GRADING & DRAINAGE PLAN

# CITY OF ALBUQUERQUE

**Re: PNM Scenic Substation, Boca Negra Dam, Grading and Drainage Plan  
Engineer's Stamp Dated 7-3-2012, (D-10/D000A)**

GRADING & DRAINAGE PLAN

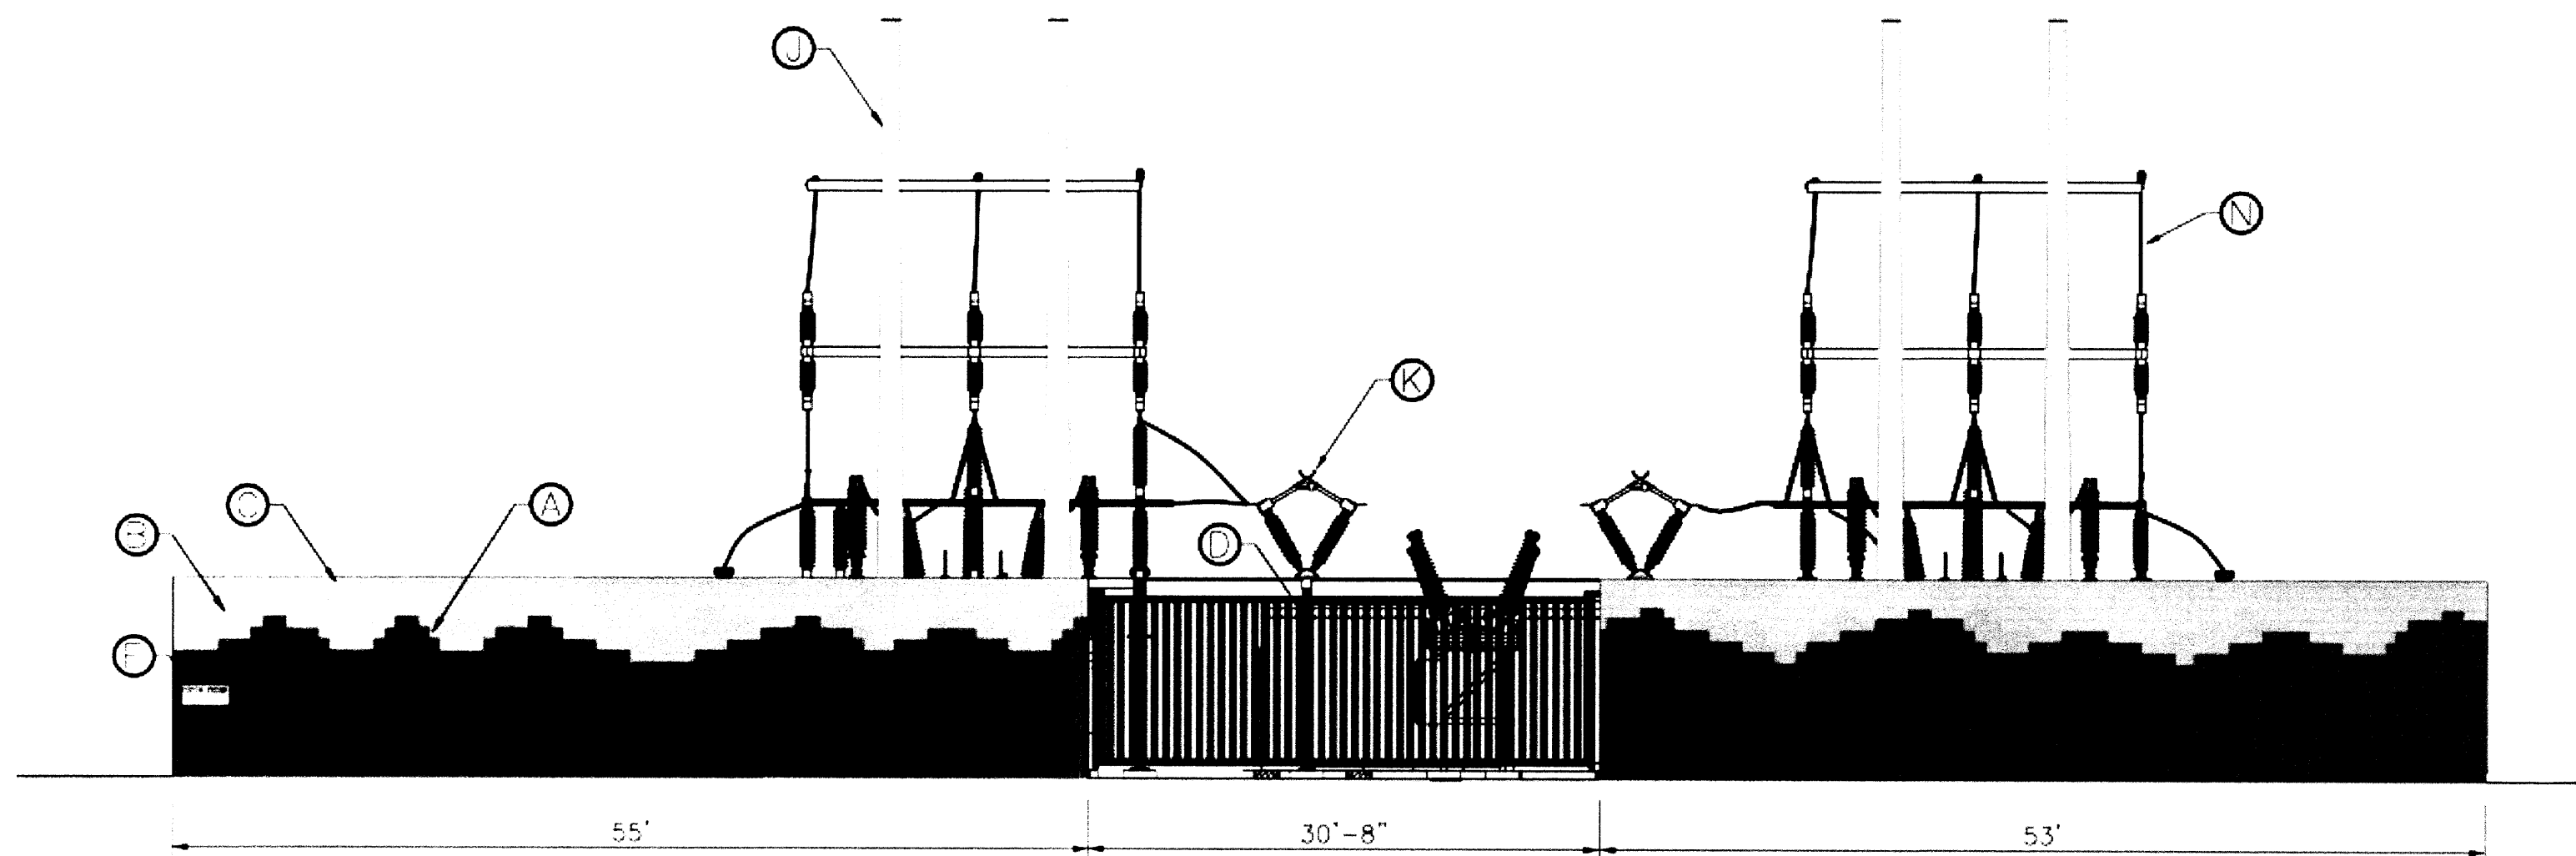
- AMAFCA approval is required for the work being accomplished inside the Boca Negra Dam Project.
- Please include the limits of the existing floodplain on the plan.
- A floodplain permit will be required for the grading taking place onsite.
- Show the 100-year and 500-year water surface elevation on the grading plan.
- Add the proposed and the existing contours in the legend.

1. **AMAFCA approval is required for the work being accomplished inside the Boca Negra Dam Project.** The Grading and Drainage Plan has been submitted to AMAFCA for approval.
2. **Please include the limits of the existing floodplain on the plan.** The existing floodplain limits have been added to the plan and included on the legend.
3. **A floodplain permit will be required for the grading taking place onsite.** A Floodplain Permit Form is included with this submittal.
4. **Show the 100-year and 500-year water surface elevation on the grading plan.** Water Surface elevations for the Dam have been added to the end of the Drainage write-up.
5. **Add the proposed and the existing contours in the legend.** Done.
